## **REVISION RESPONSE LETTER**

**RE: UTE PASS RENTAL, INC**  
**Site Development Plan**  
**File Number PPR-18-028**

**DATE:** October 23, 2018

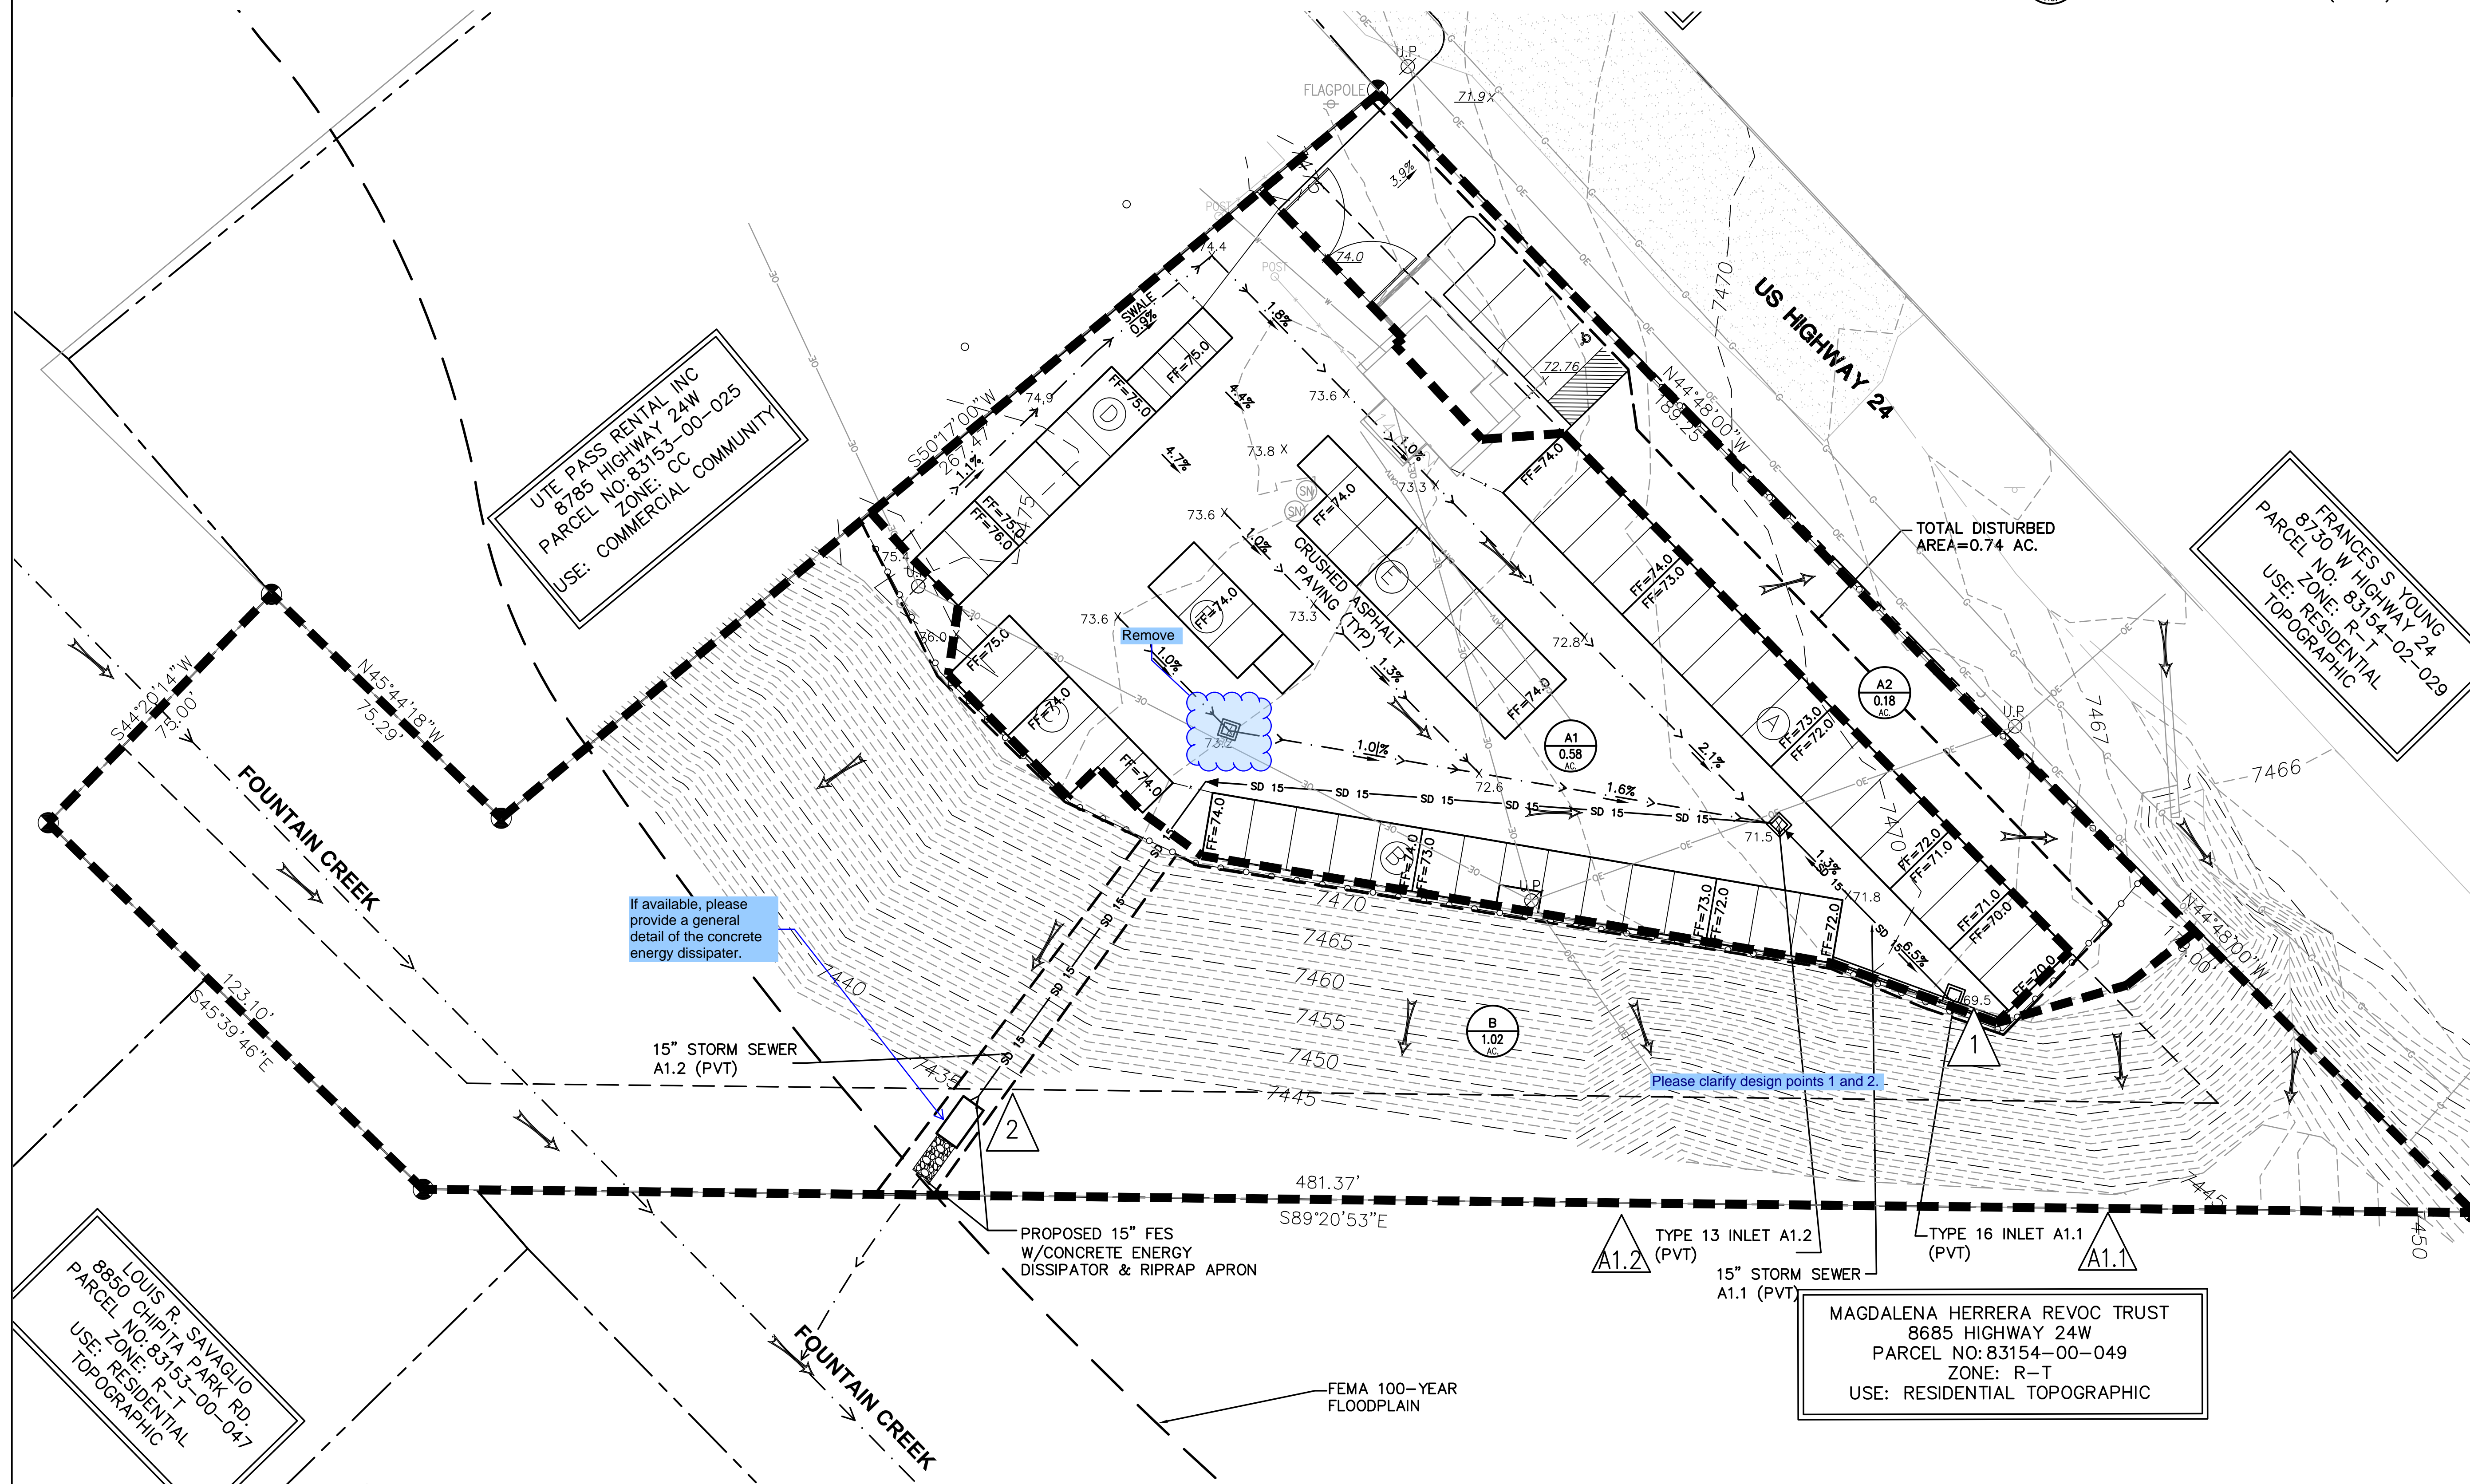
- *The drainage report from the first submittal shows an existing building around this location. Show that existing building as to be removed*
  - **In regard to the existing building, we believe it has been demolished. This structure was demolished before we were involved with this application so not sure why it was shown on the report. The drainage report has been updated to reflect this.**

1 SITE PLAN
SCALE: 1"=30'-0"

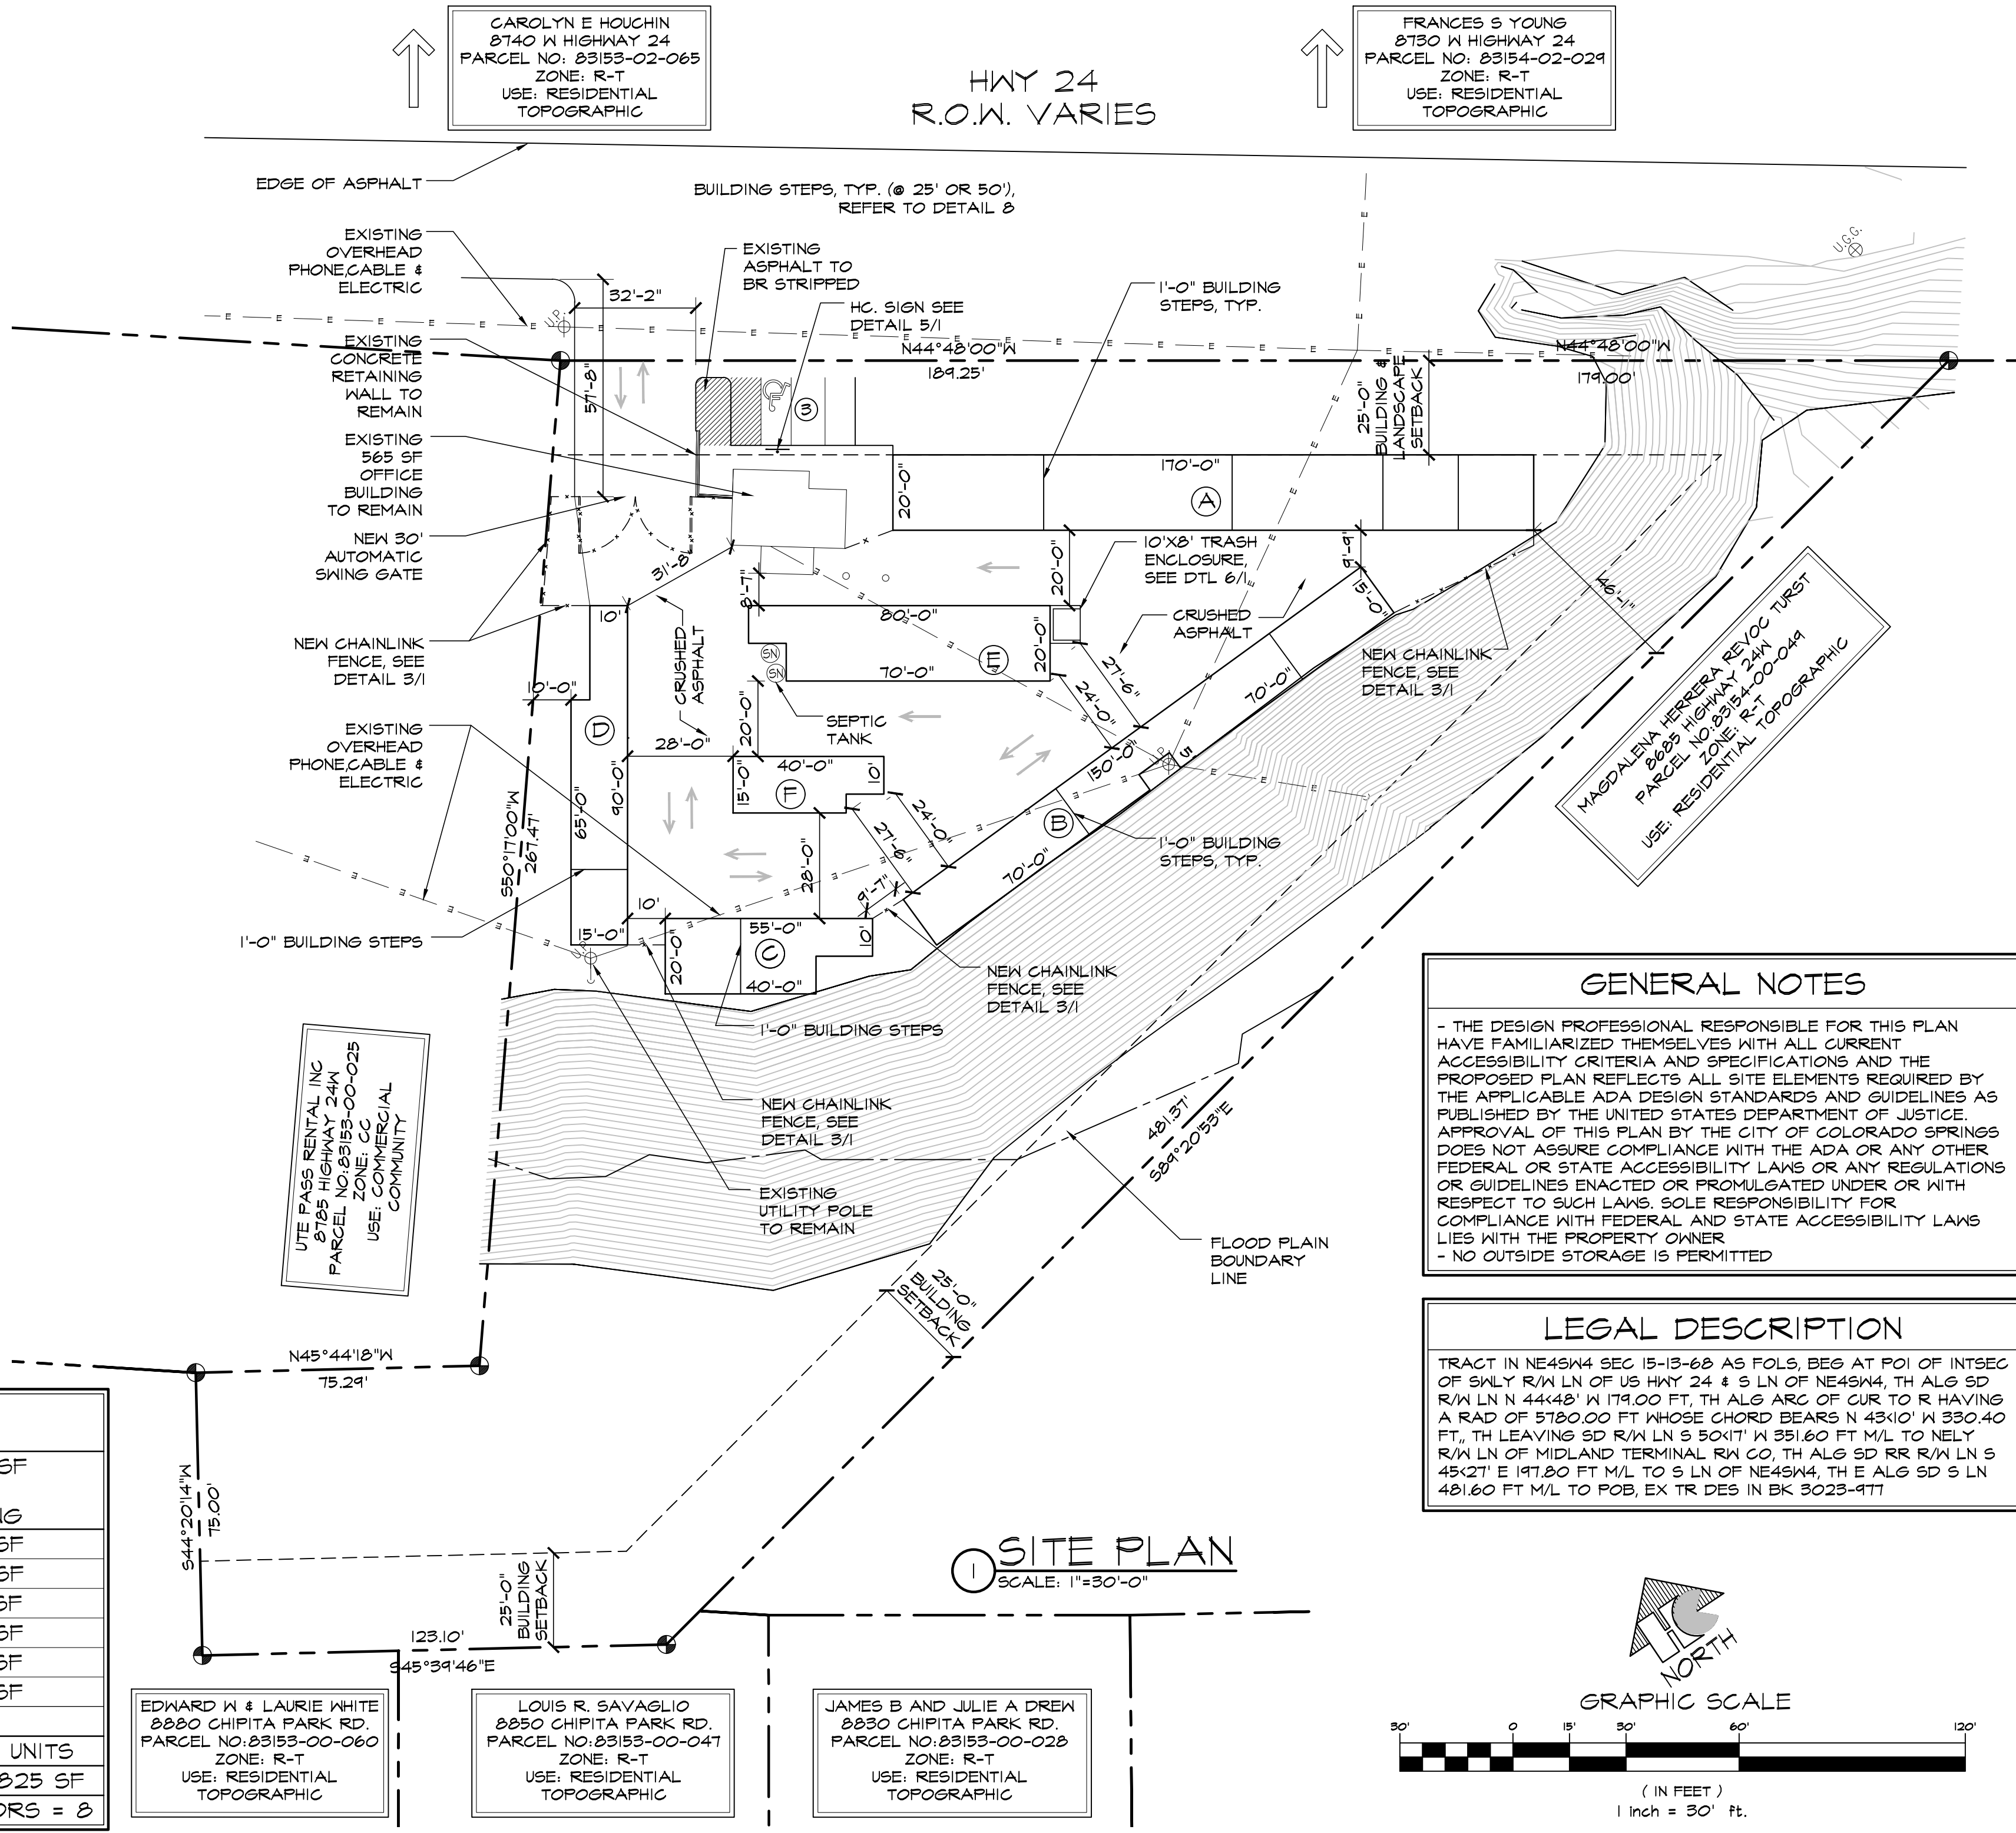
- *This does not accommodate the access issue on the SDP*
  - **The units in question will be walk up units only. We have 5' at the bare minimum in front of the last unit. This space still allows for plenty of staging area to accommodate maneuvering of storage items (boxes, furniture, etc.) via hand carrying or using a cart to haul their belongings. As mentioned, the owners will provide carts to the clients for better ease of moving their belongings for these units**

- *If trash can be generated on the site, a trash enclosure must be provided*
  - **There will be no trash enclosure on the site. The only trash being generated will be in the office which is very minimal and the owner will take this trash with them to dispose of properly themselves. The storage use does not generate any trash. People will store their belongings in the unit and remove them when they are done. Therefore, no trash is generated from this use.**

- *Is this line the existing C & G along Hwy 24? If so, please label as such*
  - **There is no curb and gutter along Hwy 24. This is edge of asphalt and has been labeled as such**
